WEST SUSSEX COUNTY COUNCIL CONSULTATION

TO:	Arun District Council FAO:David Easton
FROM:	WSCC Highways - Public Rights of Way
DATE:	11 July 2022
LOCATION:	Bognor Regis Golf Club Downview Road Bognor Regis PO22 8JD
SUBJECT:	FP/274/21/OUT Outline planning application with all matters reserved, except means of access, for the erection of up to 480 new homes (C3), the formation of a new means of access onto Golf Links Road, together with the creation of new surface water drainage, new landscaping and habitat creation, ground works and other infrastructure and the retention and re-purposing of the retained club house (F2). This site also lies within the parish of Yapton, affects a Public Right of Way and is a Departure from the Development Plan. This application is subject to an Environmental Statement.
DATE OF SITE VISIT:	n/a
RELEVANT PUBLIC RIGHTS OF WAY NUMBER(S):	FP153
RECOMMENDATION:	No Objection (With Conditions)
S106 CONTRIBUTION TOTAL:	n/a

designed by	checked by	date
LJM	NJE	14 Dec 21
scale	paper size	
1:2000	A1	
job/dwg no.	rev.	
171-UW-P-A-009	A

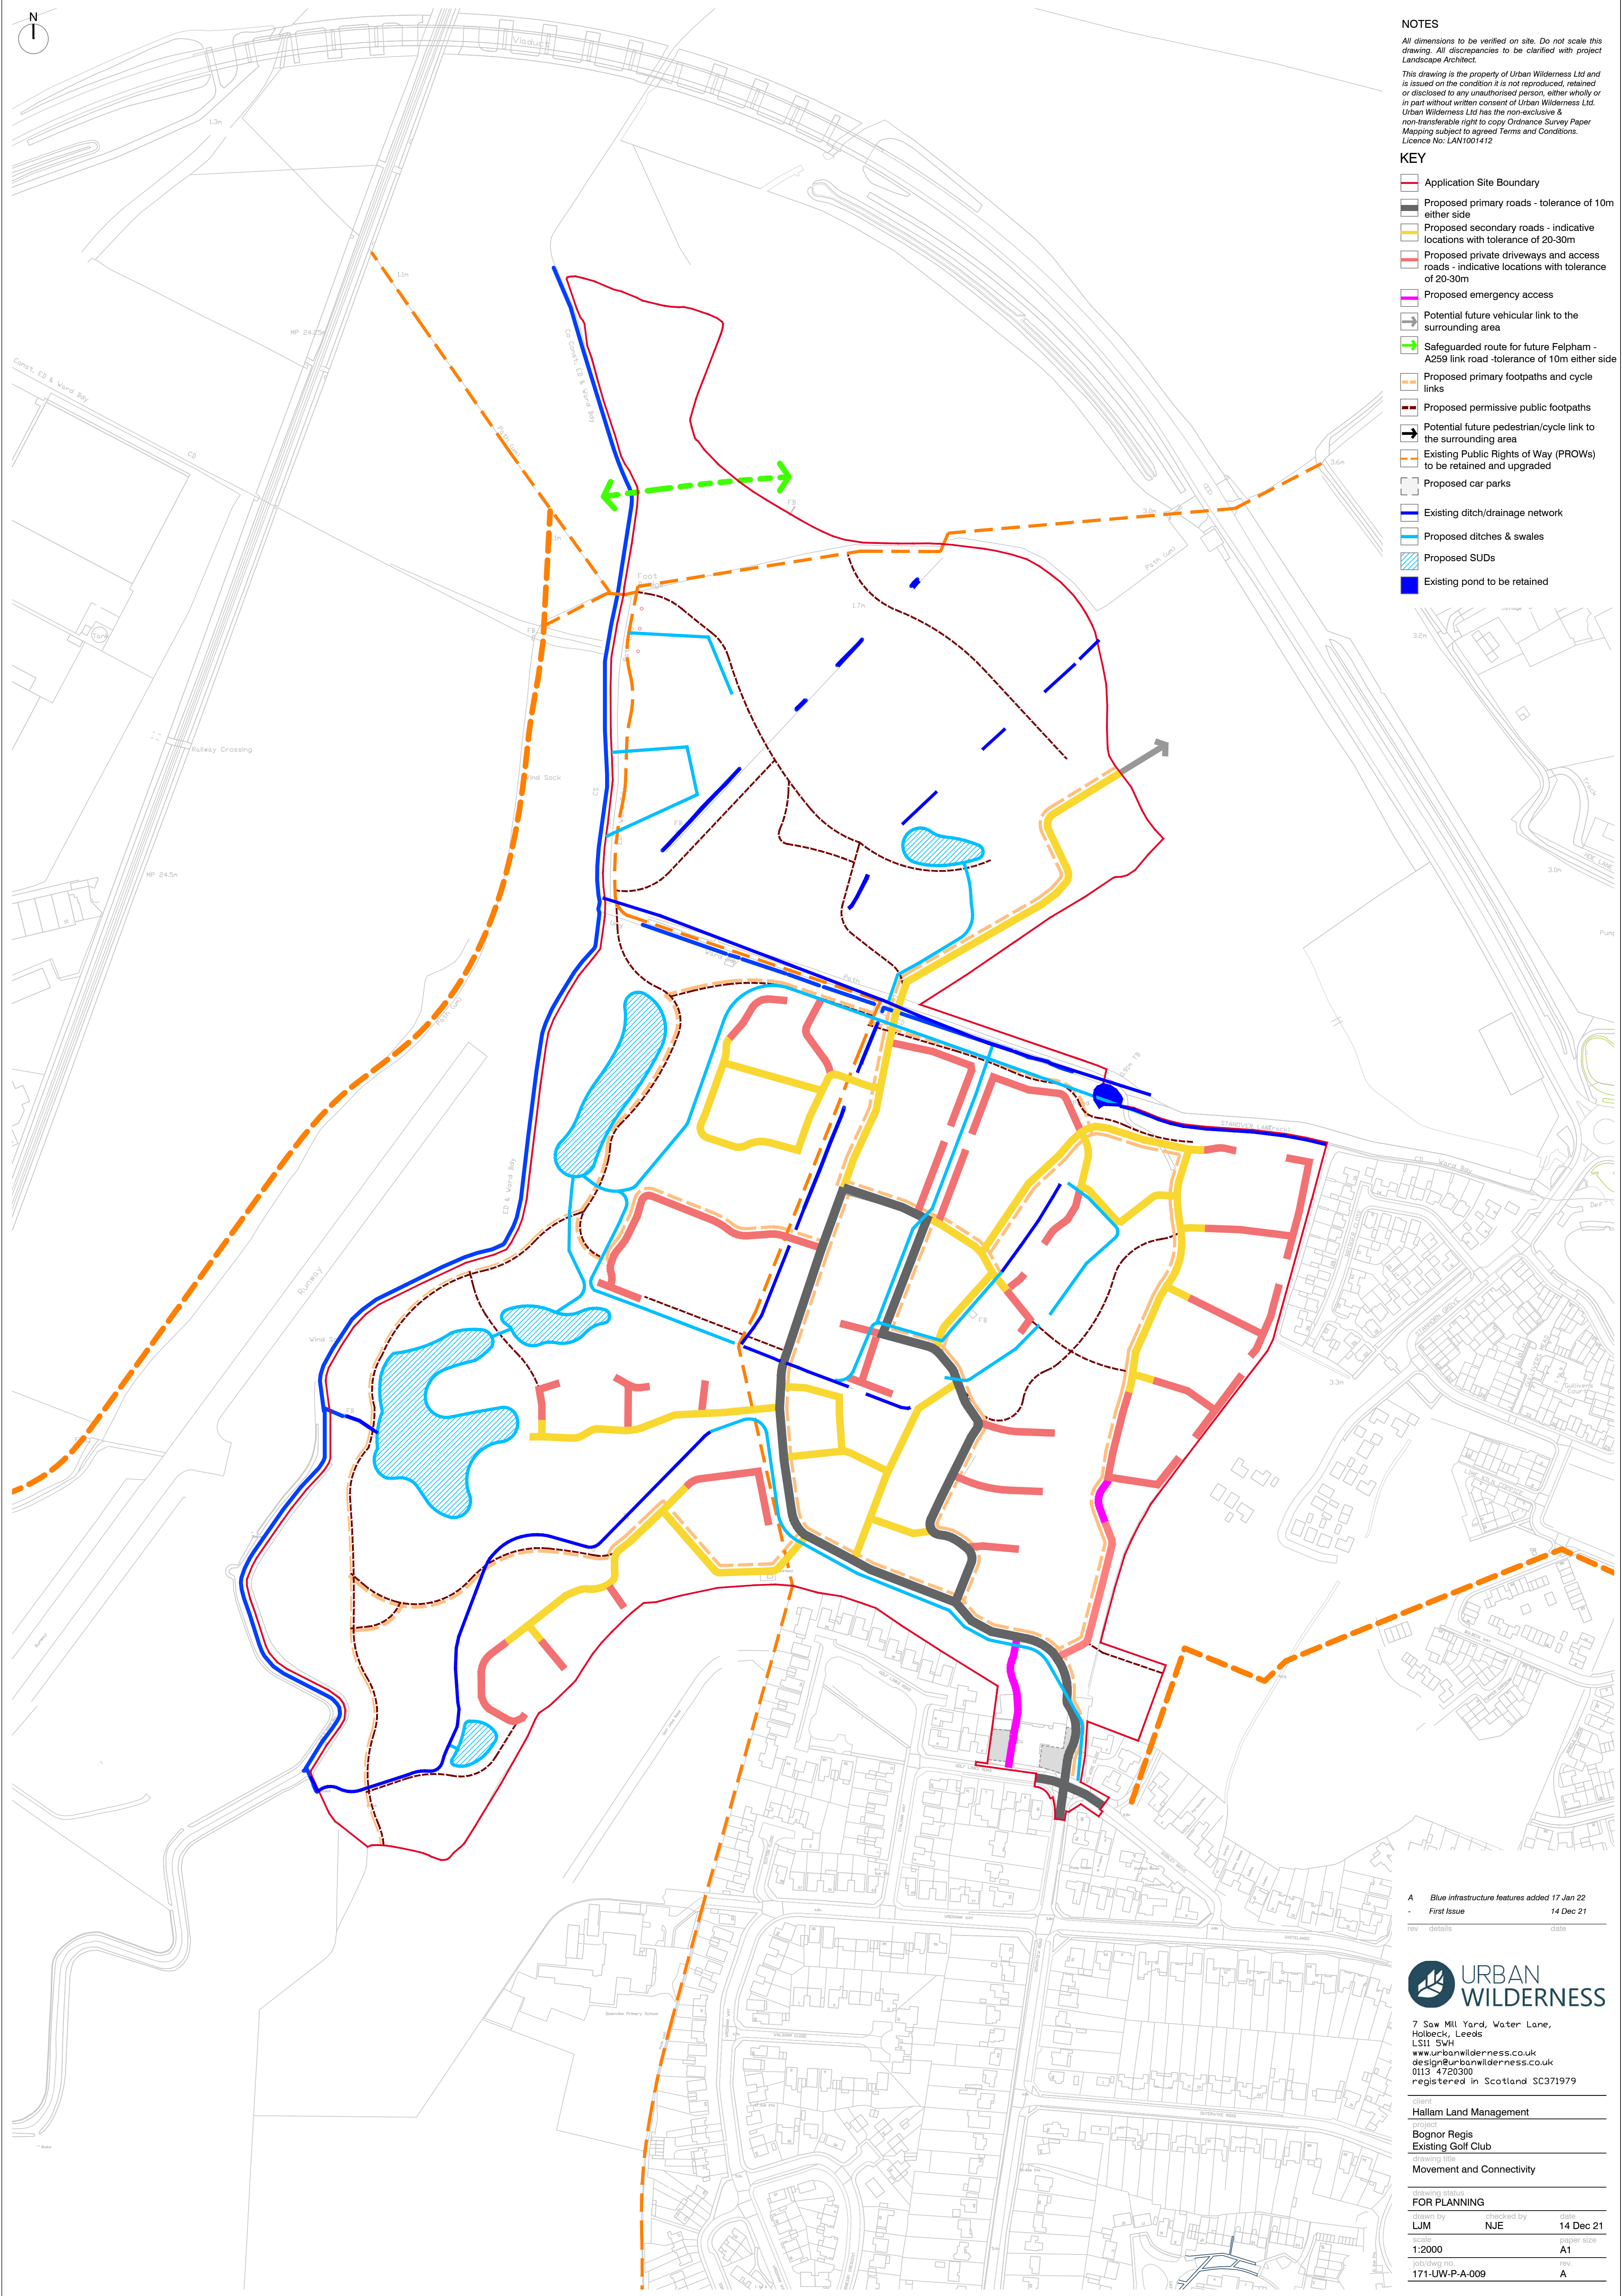
I note the addition of Proposed Permissive Footpaths on the Movement and Connectivity Parameter Plan (171-UW-P-A-009 Rev B). Whilst I welcome these, please note that Public Rights of Way would not look to adopt these as formal PROW and the responsibility for maintaining them should remain with the developer.

I particularly note one that has the potential to connect with FP154, east of the site's south-eastern boundary. Is it the developer's intention to seek landowner agreement for the small gap between the two, so as to create a useful connection?
